Loft conversion & single storey rear extension (re-submission of EP/89/18/HH).

39 Hillview Crescent East Preston

Thank you for your internet representation made on 1st October 2018 which has been recorded as '**an objection**' with the comments as follows:

DRW NO 8a SCALE 1/50 (A3)
PROPOSED SECTION

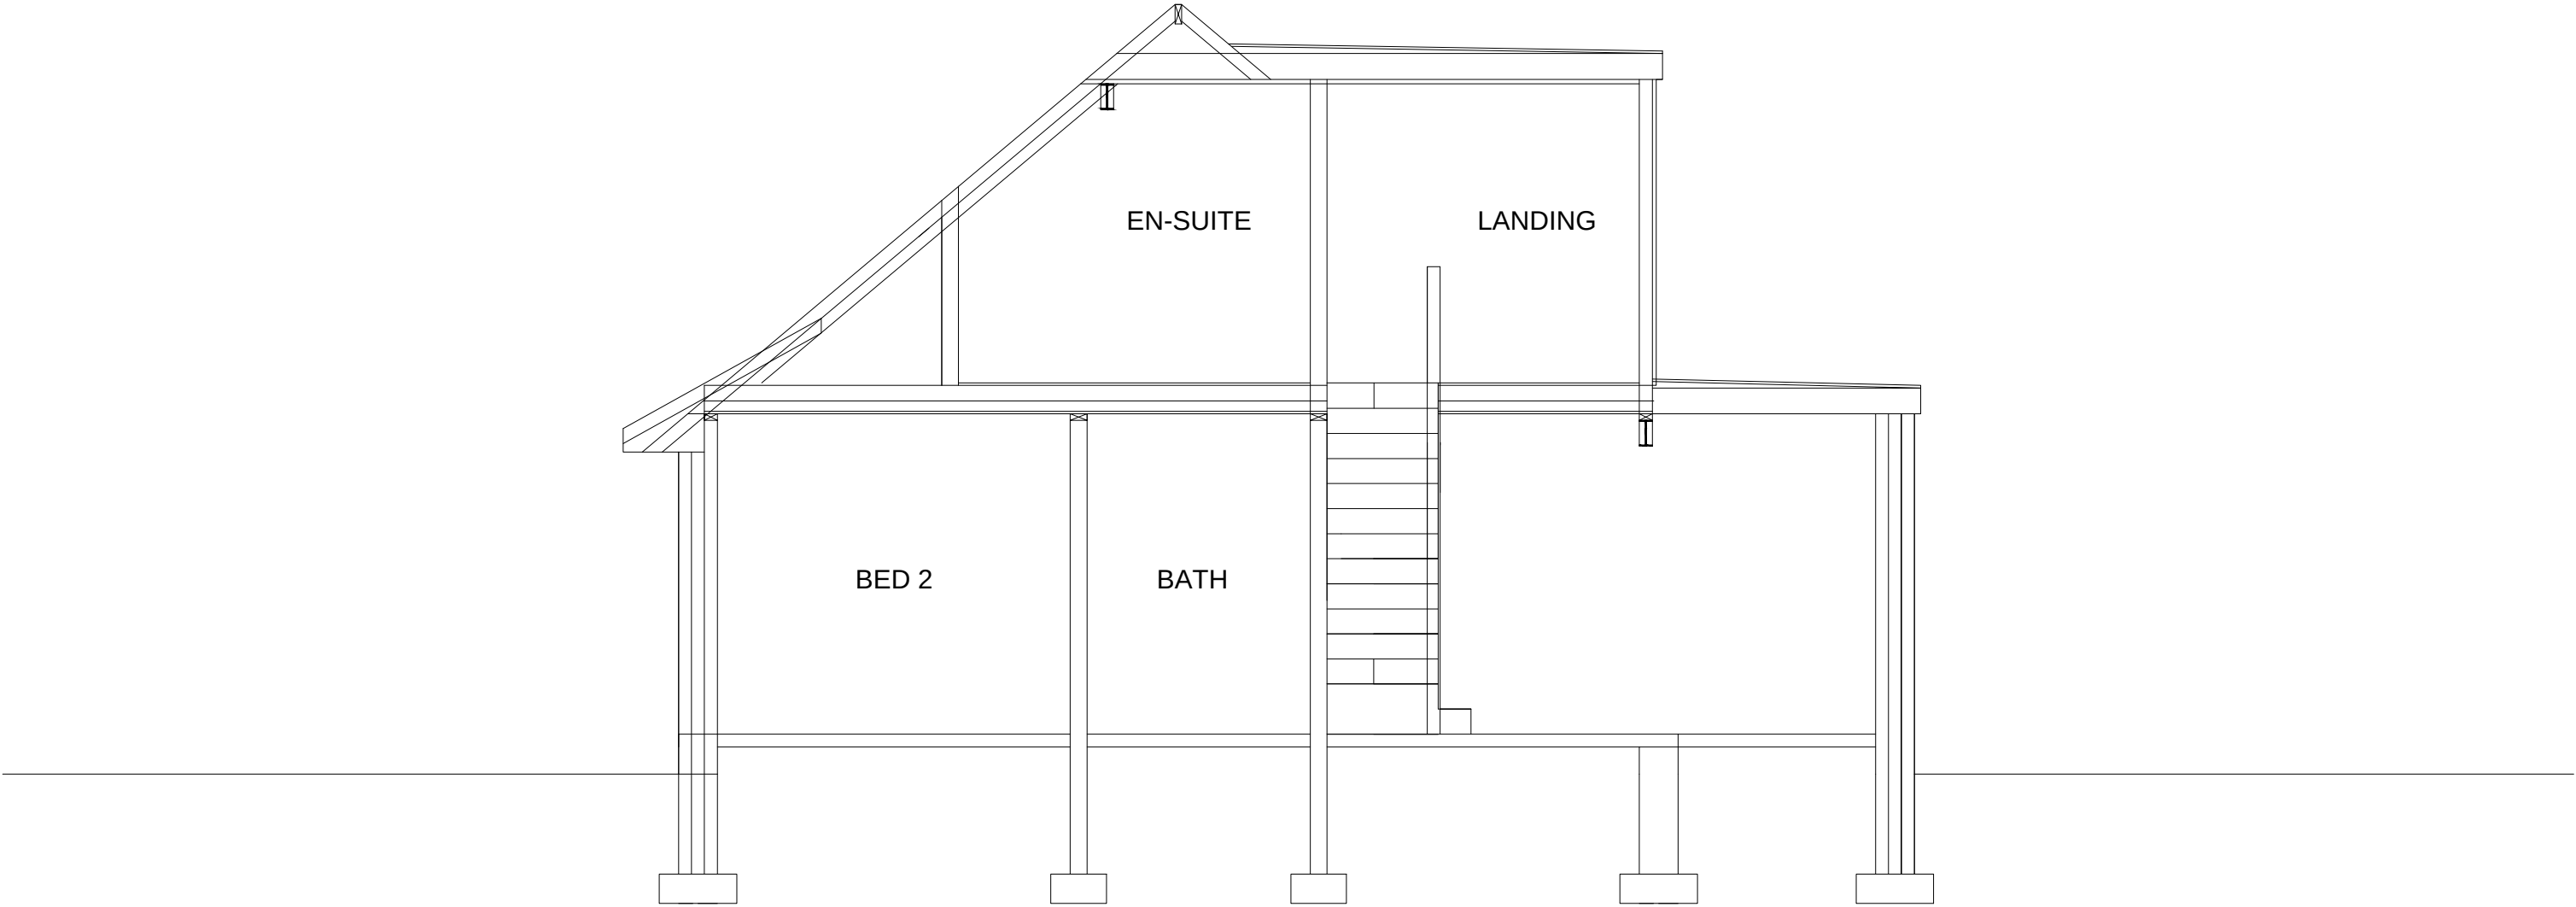
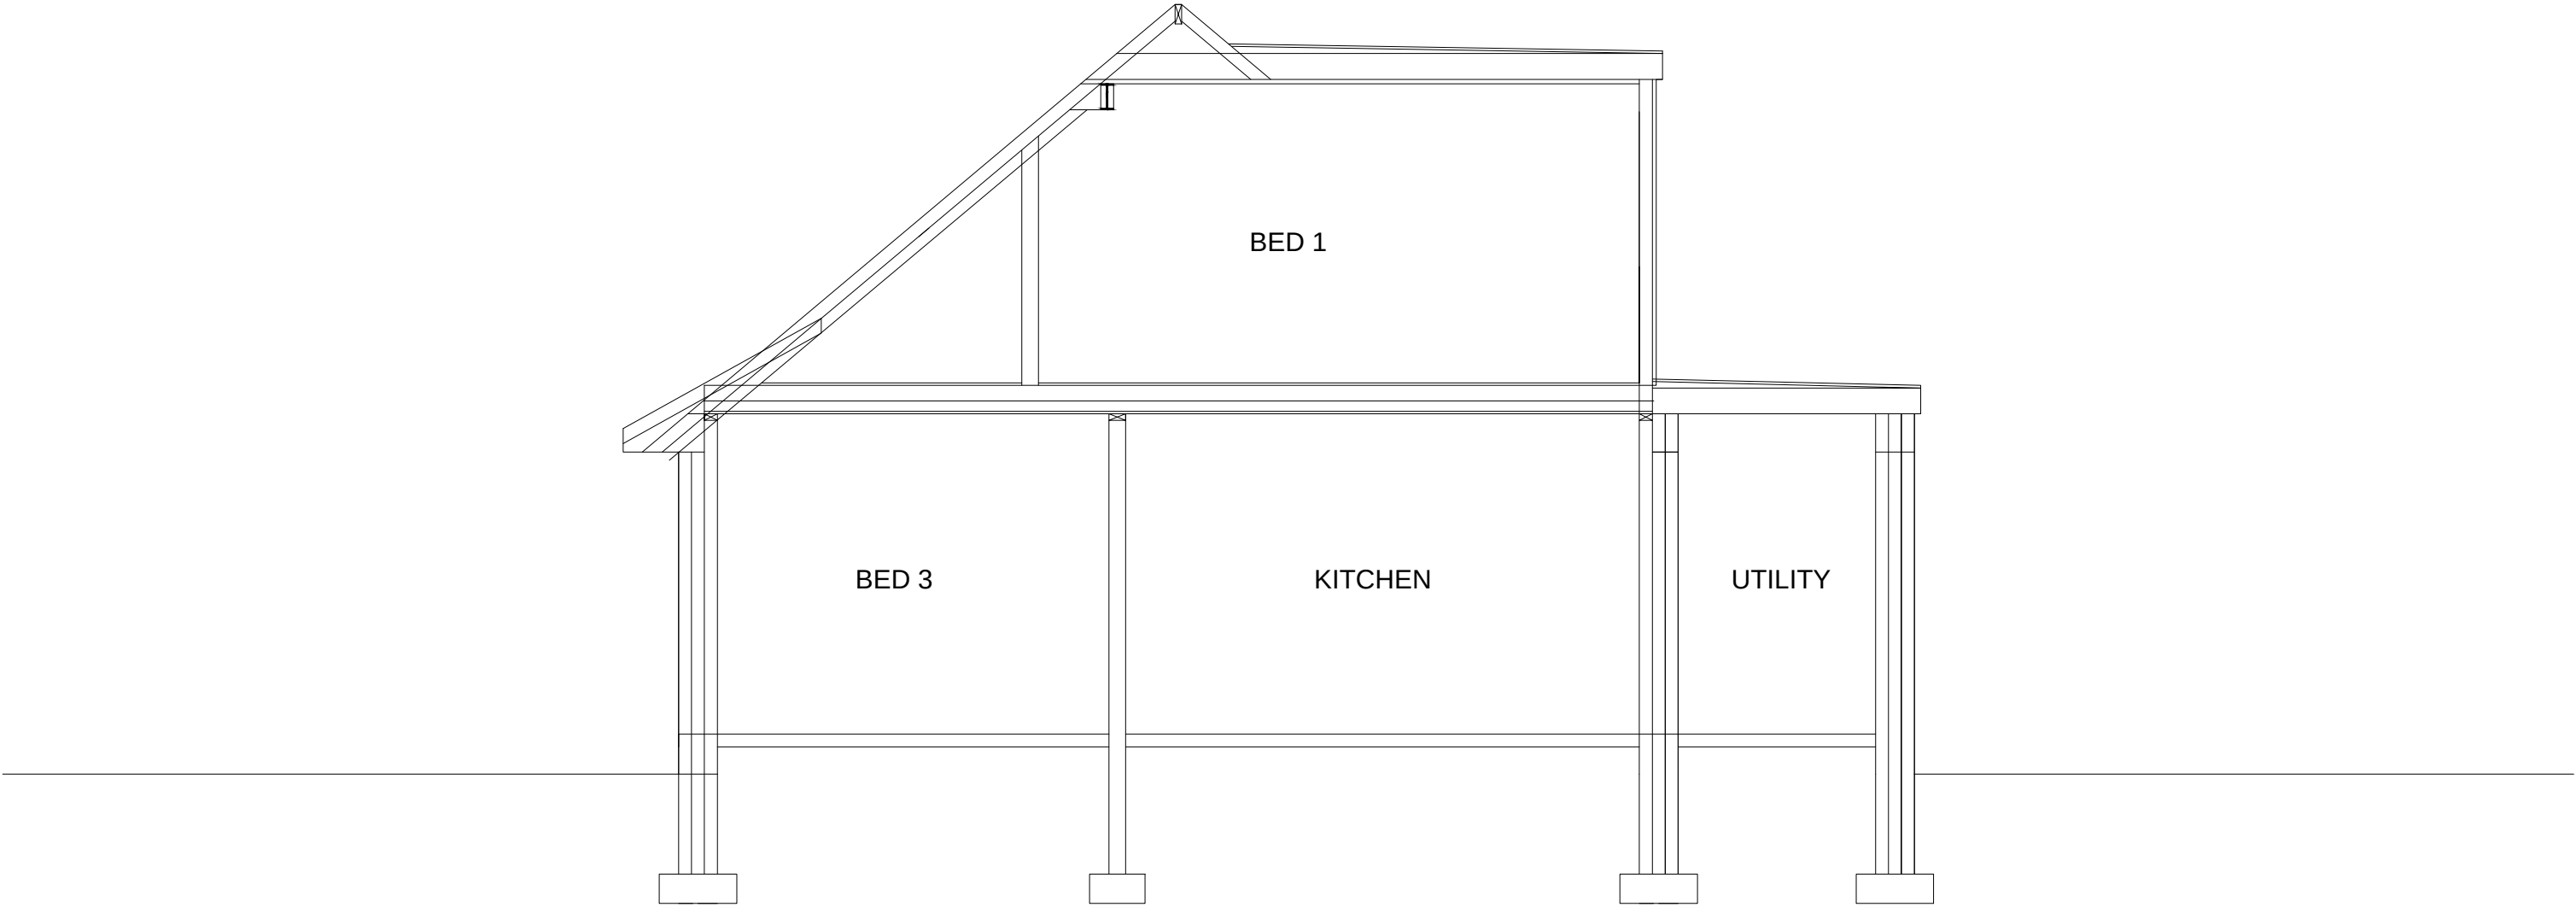
The application would convert a bungalow with a high pitched pyramidal roof into a semi-bungalow with a long ridge and vestigial hips. A large dormer occupies nearly all the rear of the roof. The appearance of the building has therefore been transformed. The resulting structure can only be called unattractive. It is also out of character with its surroundings.

In the Arun Local Plan, this application is therefore contrary to policy D SP1 because it does not reflect the characteristics of the local area; D DM1, because it detracts from the area's character and does not demonstrate a high standard of architectural principles; and D DM4, because the enlarged building bears no resemblance to the old building. In the East Preston Neighbourhood Plan, it is contrary to Policy 1, because it does not reflect the architectural and historic character of the surrounding buildings, and the new roof does not look as if it was part of the original design of the house; and Policy 3, because the basic form of the roof has been altered.
